From: Sue Howell
Sent: 24 April 2017 16:54
To: Planning.Responses
Cc: Claire Potts
Subject: RE: Planning Consultation on FP/145/16/DOC

NOTIFICATION FROM ARUN DISTRICT COUNCIL
TOWN AND COUNTRY PLANNING ACT 1990
APPLICATION FP/145/16/DOC

Site Address: Site 6 Phase 5A Land north of Felpham PO22
8FX

Description of Works: Application for approval of matters reserved by condition imposed under FP/90/13/ relating to condition 4 - surface water drainage & 8 - landscape scheme.

Scale
1 : 250@A0
Drawing No.
D1530.L.901

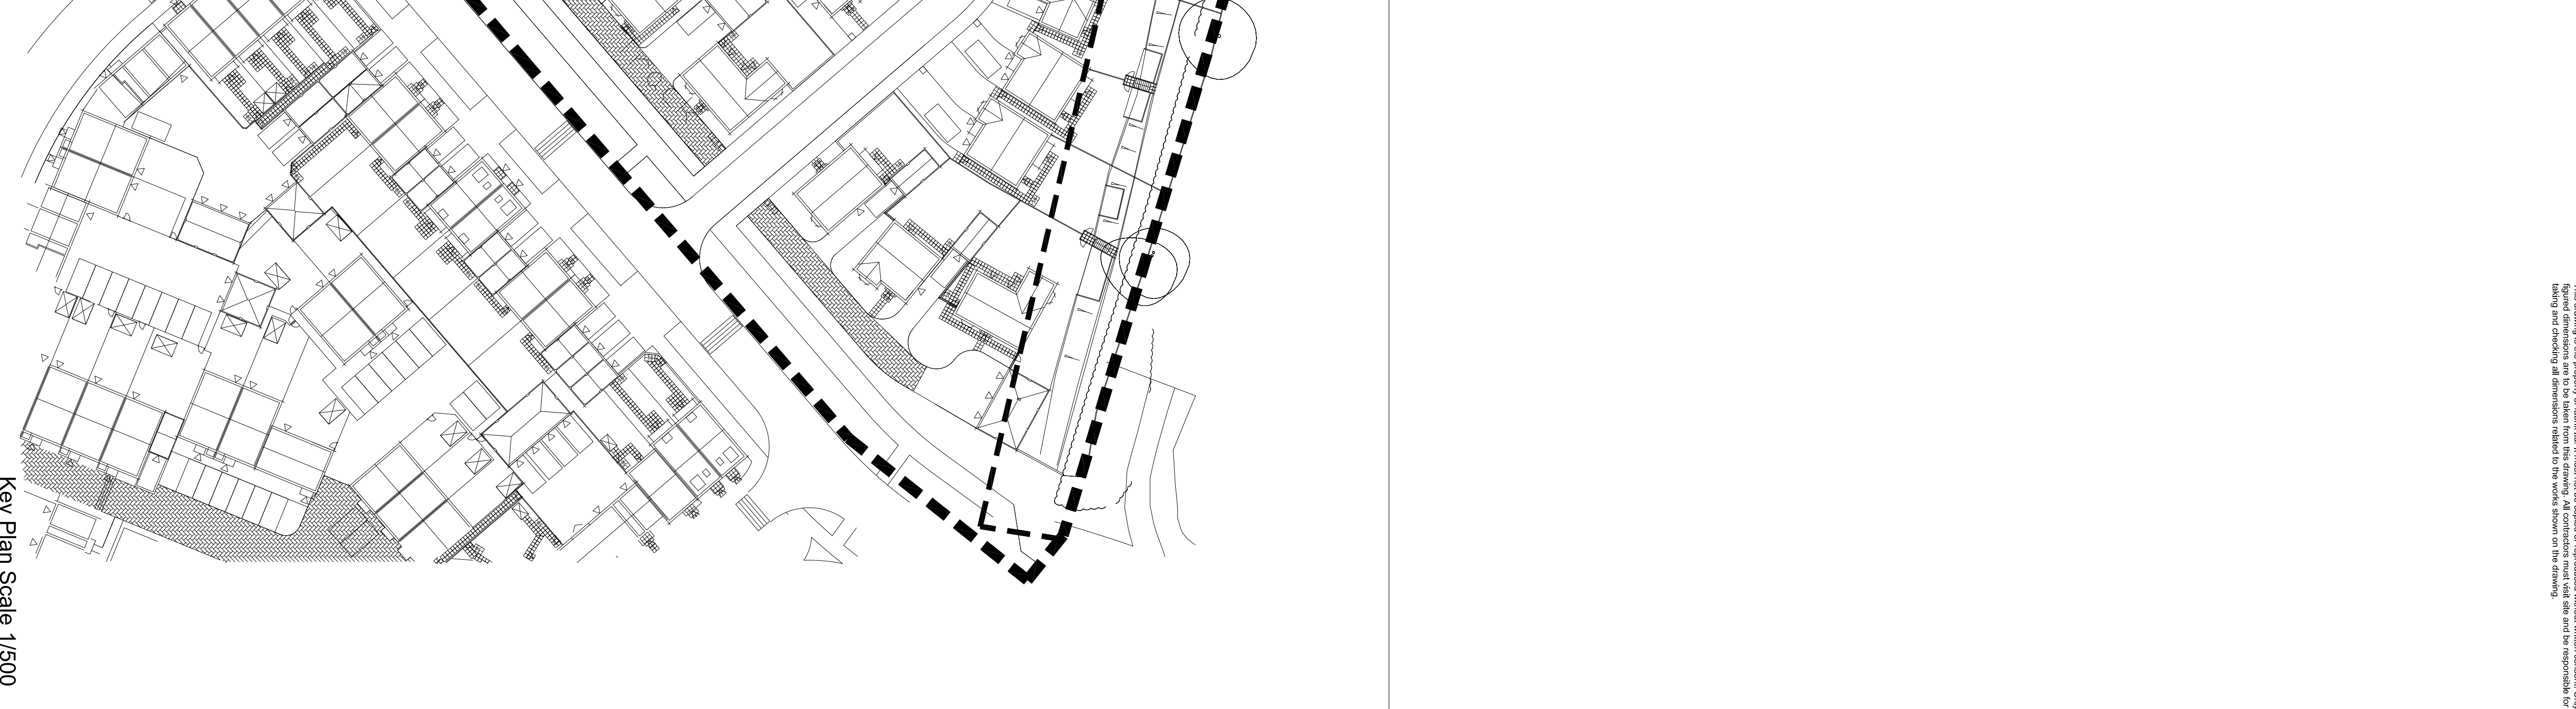
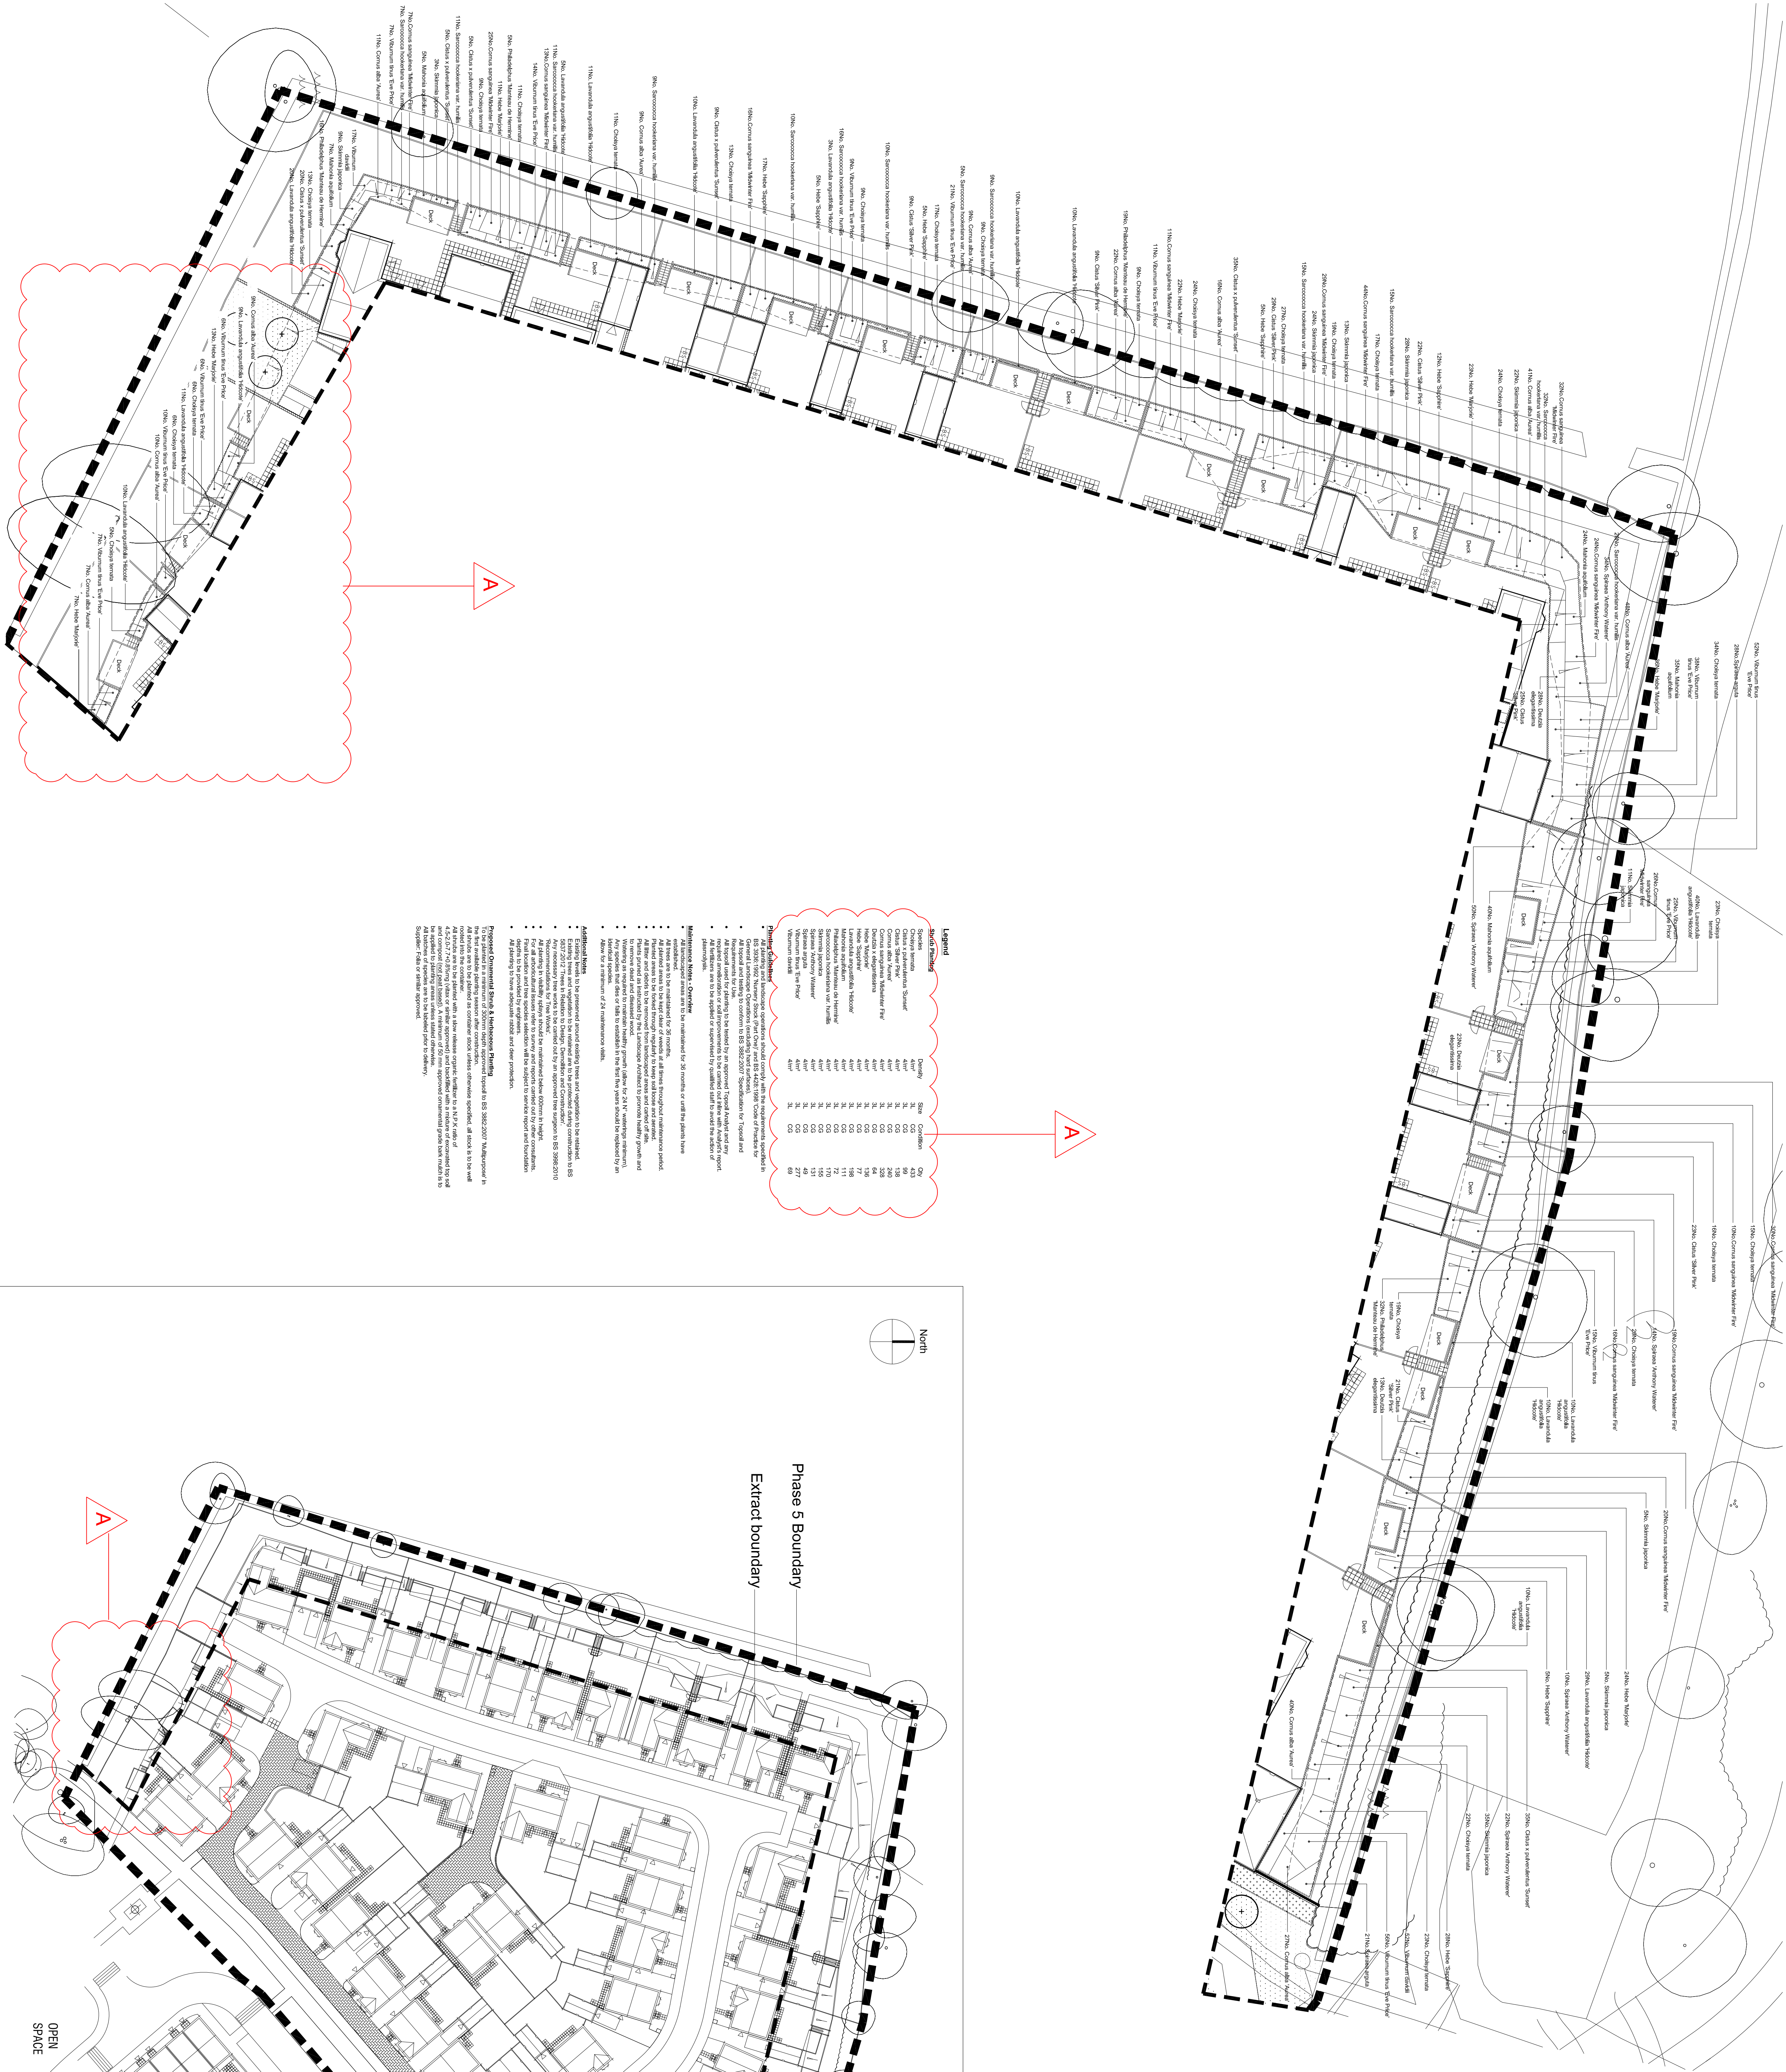
We confirm that the details submitted in the Phase 5A drawings D 1530.L.700, D1530.L.901, D1430.L.902 do show an appropriate and approved landscape scheme, with details of existing trees and hedgerows on the land to be retained and measures for their protection in the course of the development.

From the details submitted we **confirm that we would recommend the discharge of Condition 8** – Landscape scheme on application FP/145/16/DOC following grant of permission imposed under FP/90/13.
